**From:** Holly Duncan  
**Sent:** Friday, September 09, 2011 2:51 PM  
**To:** Jeff Watson  
**Subject:** RE: BL-11-00016 Kohl

**From:** Jeff Watson  
**Sent:** Friday, September 02, 2011 3:29 PM  
**To:** Christina Wollman; Brenda Larsen; Jan Ollivier; Holly Duncan  
**Subject:** BL-11-00016 Kohl

BOUNDARY LINE ADJUSTMENT		
PREPARED FOR PETER KOHL		
A PORTION OF THE SW 1/4 OF THE NE 1/4 OF SECTION 4, TOWNSHIP 19 NORTH, RANGE 15 EAST, W.M.		
KITTITAS COUNTY	DATE	JOB NO.
DWN BY G. WEISER	08/2011	046902
CHKD BY	SCALE	SHEET
D. PIERCE	1"=100'	1 OF 1

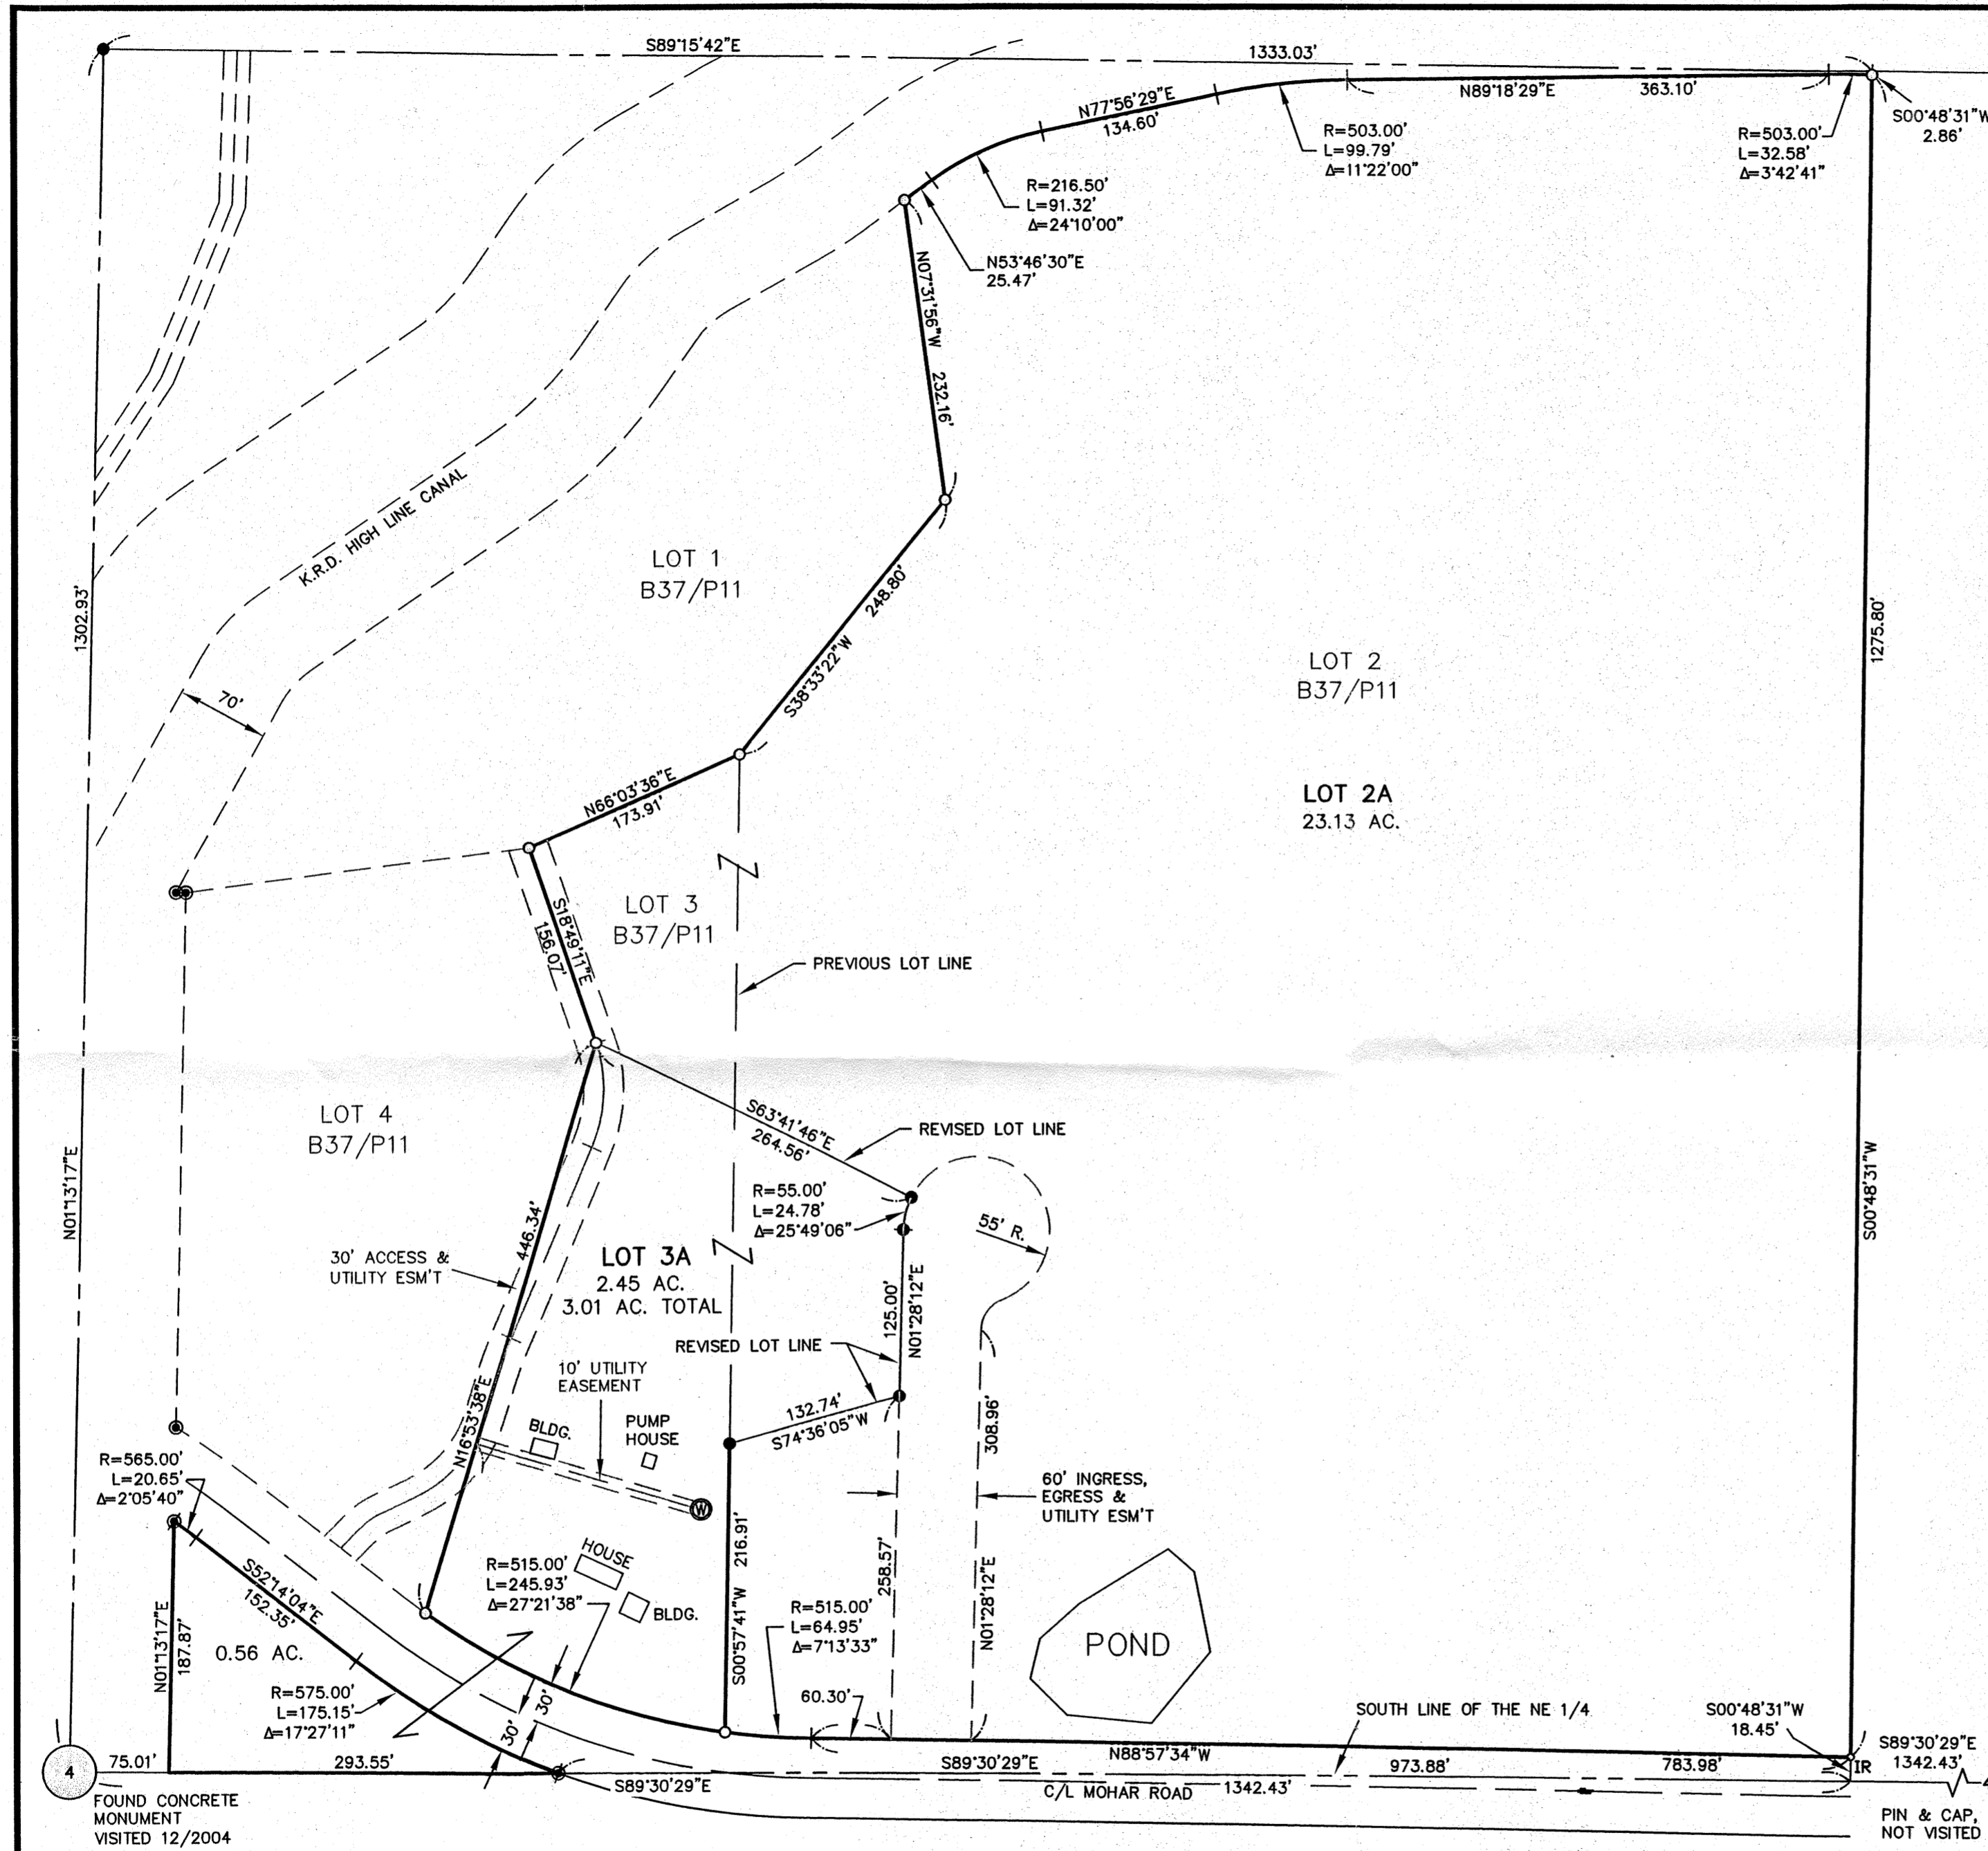
It looks like this BL won't be a problem for EH. It doesn't appear the well is the required 50 feet from the original property line but that part of the line isn't changing from what it was so is a mute point.
